Appeal Decision

Appeal Ref: APP/R5510/D/21/3278945

24 Grasmere Avenue, Ruislip, Middx HA4 7PJ

- The appeal is made under section 78 of the Town and Country Planning Act 1990 against a refusal to grant planning permission.
- The appeal is made by Mr & Mrs M Thorpe against the decision of the Council of the London Borough of Hillingdon.
- The application Ref: 75778/APP/2021/885 dated 5 March 2021, was refused by notice dated 28 April 2021.
- The development proposed is single storey side/rear extension raising the ridge height to provide habitable use with side/dormers and internal alterations following refusal 75778/APP/2020/3677.

proposed  
street scene

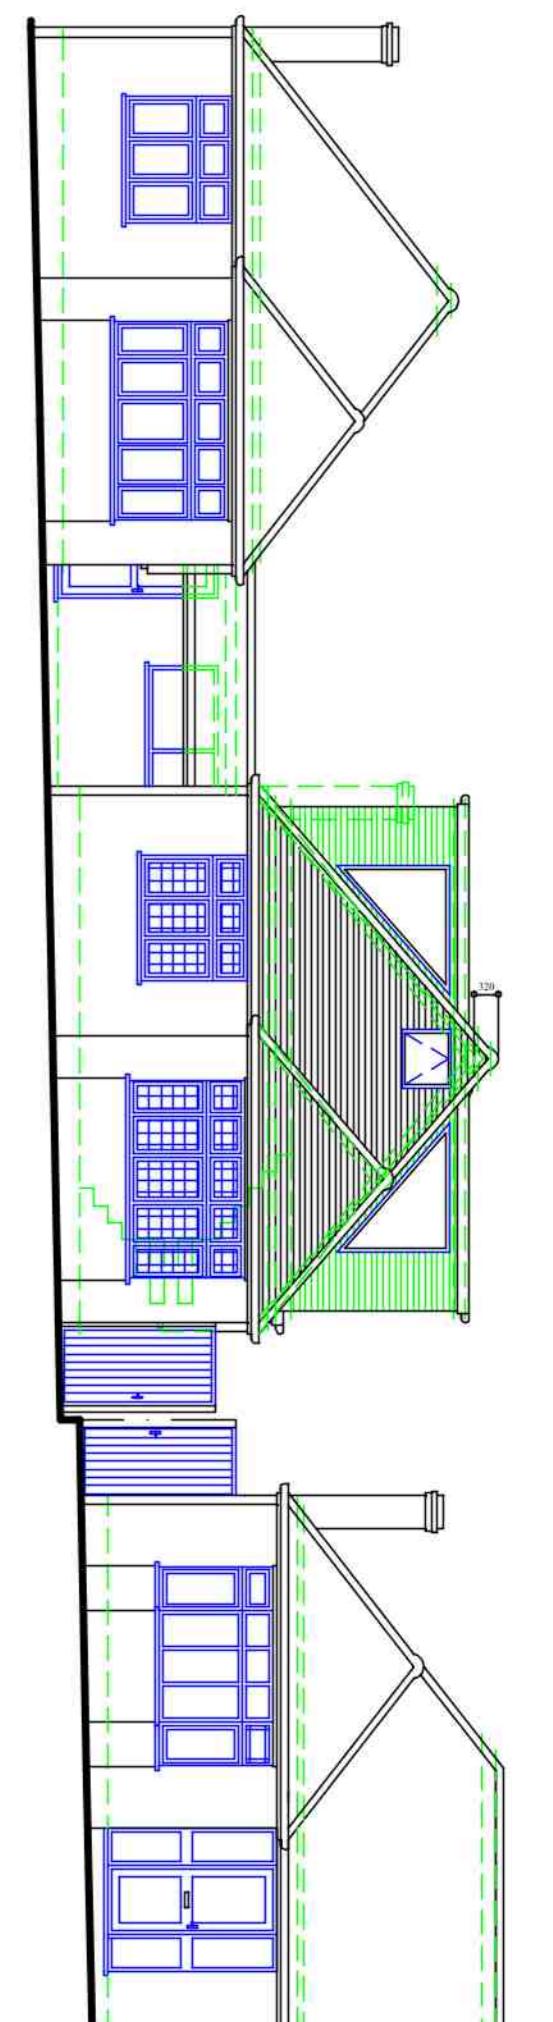
7. As a result, the property as proposed to be extended would also appear visually intrusive and over dominant in the street scene. This would harm the character and appearance of the local area.

Scale 1:50 1:100 @ A1
Date February 2021
Drawn By D. J. BLYTH.
Drawing No: **BD/21/03/3A**

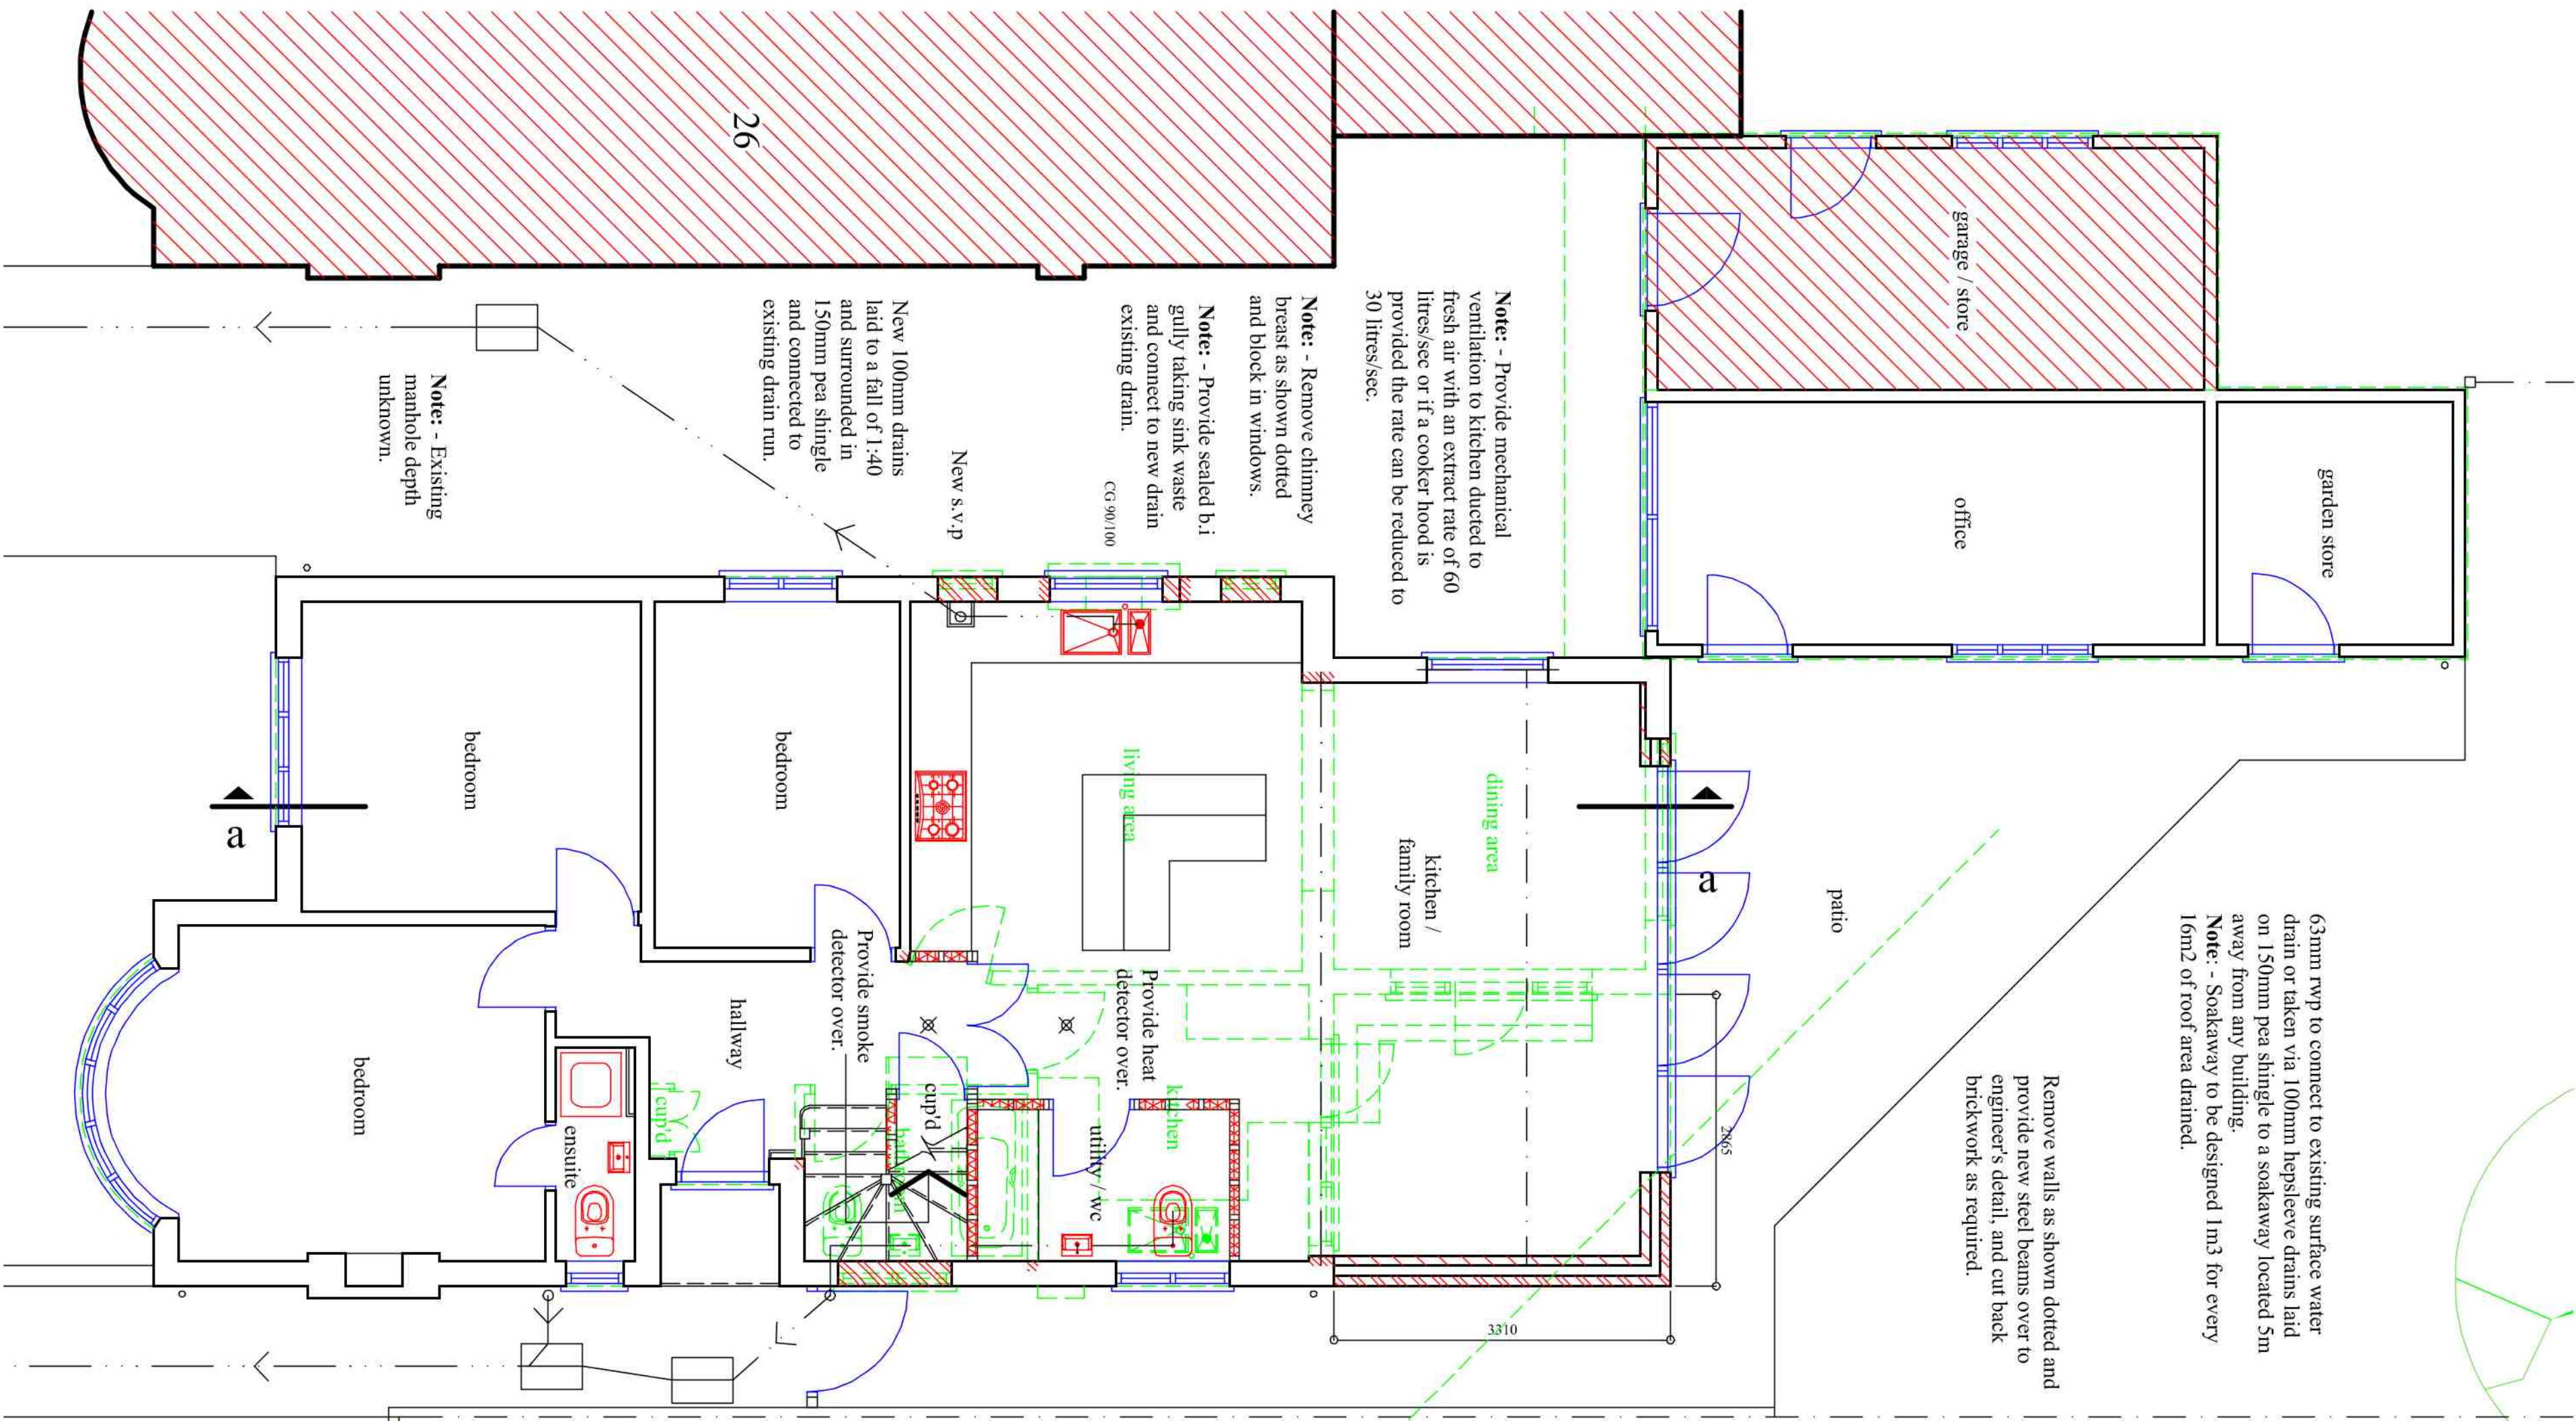
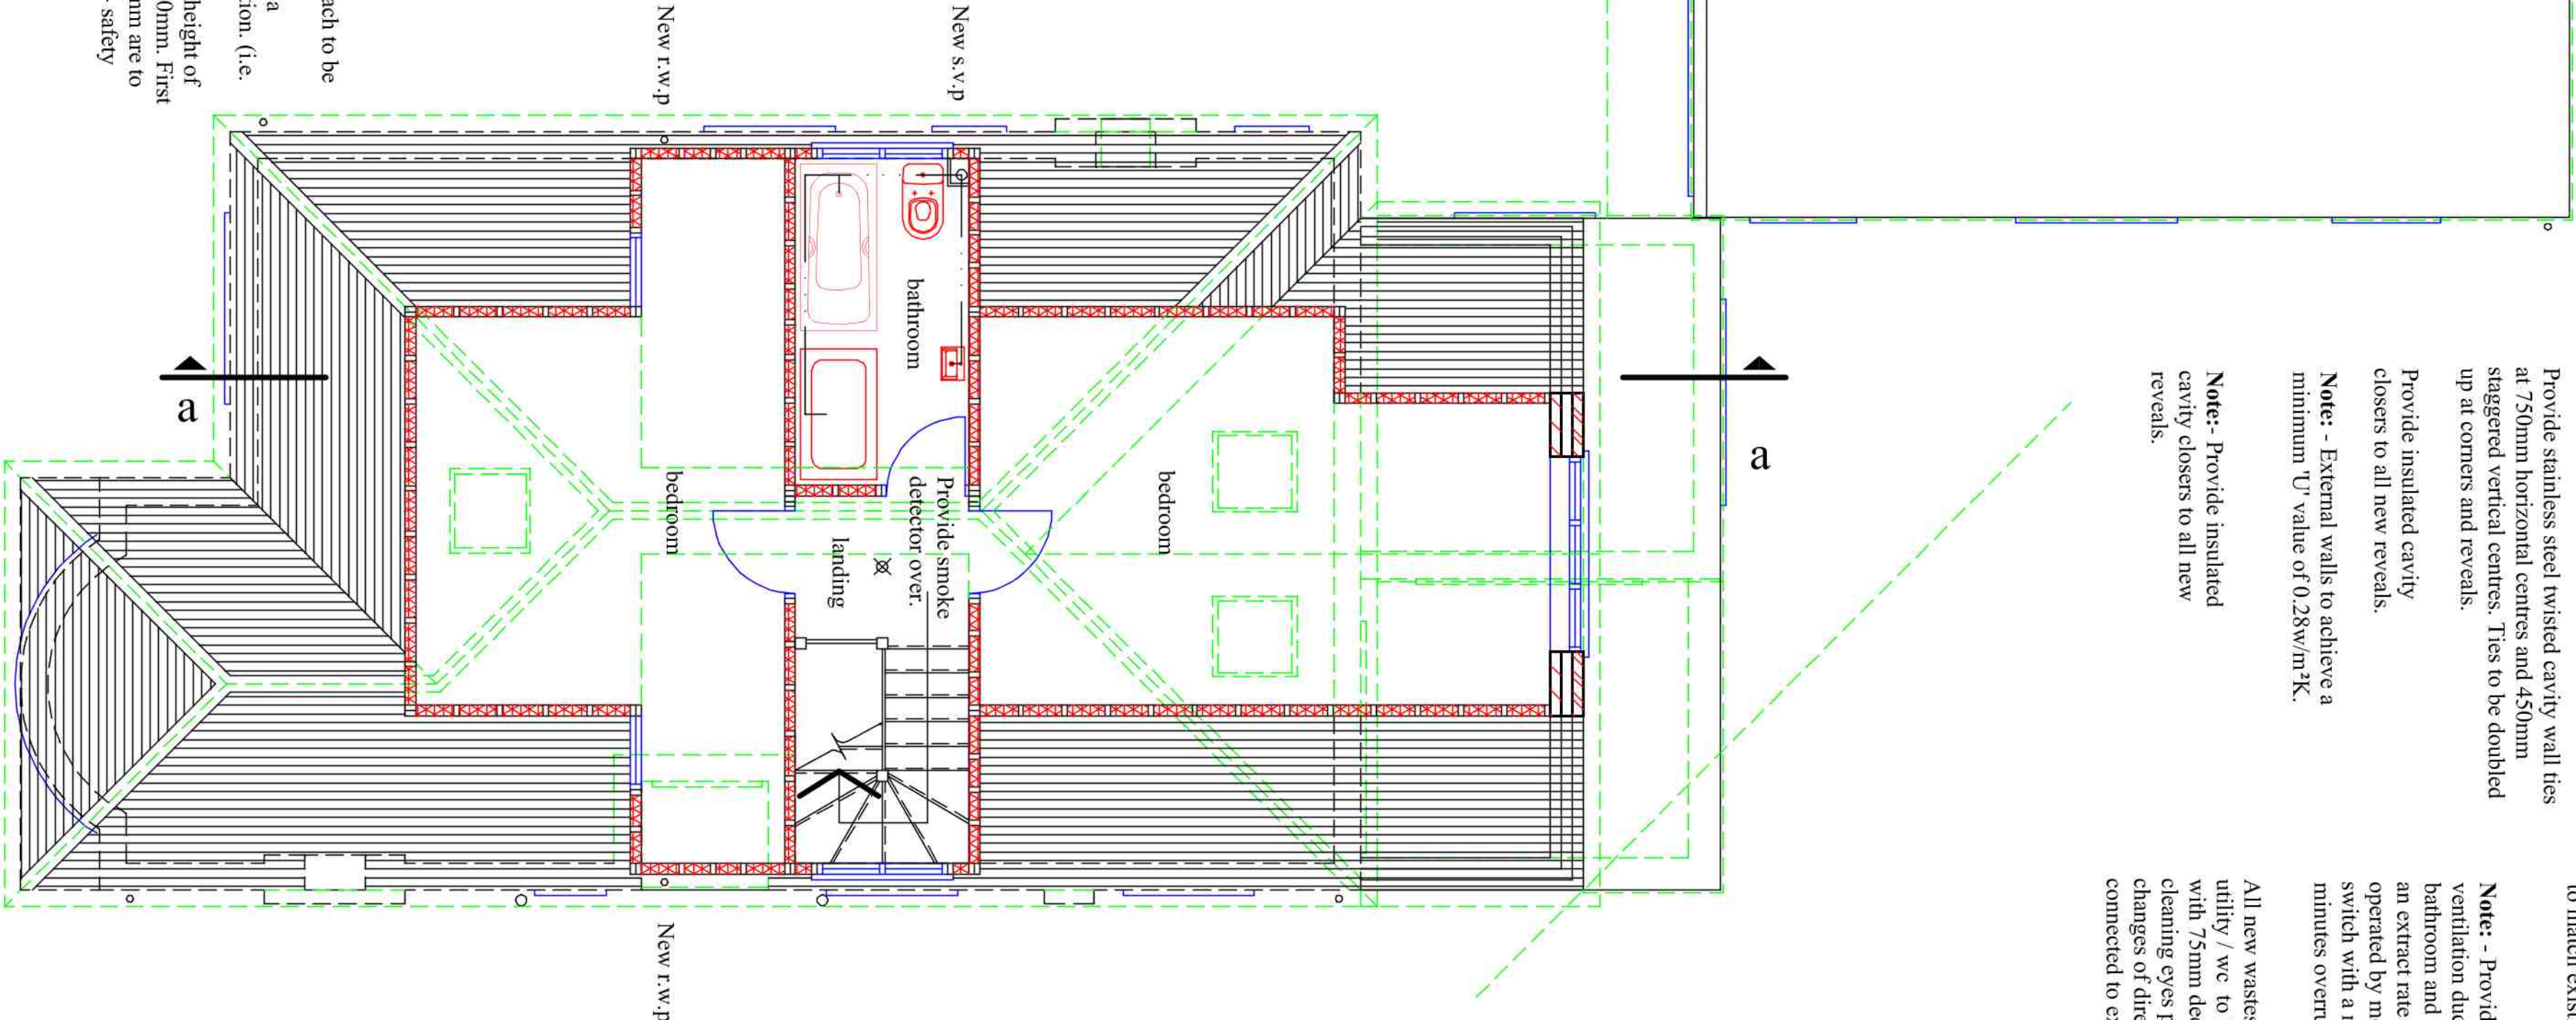
6. The proposed dormers would be set back from the front elevation and would be centrally sited within the side pitch of the main roof. However, there would be very limited inset from either the new ridge line or the eaves line. With their flat roofs the proposed side dormers would create a very bulky and box-like appearance at roof level. The extended roof with these proposed side dormers would be top heavy in relation to the modest proportions of the dwelling.

8. I therefore conclude that the proposed development, and in particular the side dormers would harm the character and appearance of the existing property and of the local area. This would conflict with Policy BE1 of the Hillingdon Local Plan: Part One – Strategic Policies (2012) and Policies DHMB11, DHMB12 and DMHD1 of the Hillingdon Local Plan: Part Two – Development Management Policies (2020) as well as the Framework and in particular Section 12, all of which seek a high standard of design which respects the local context.
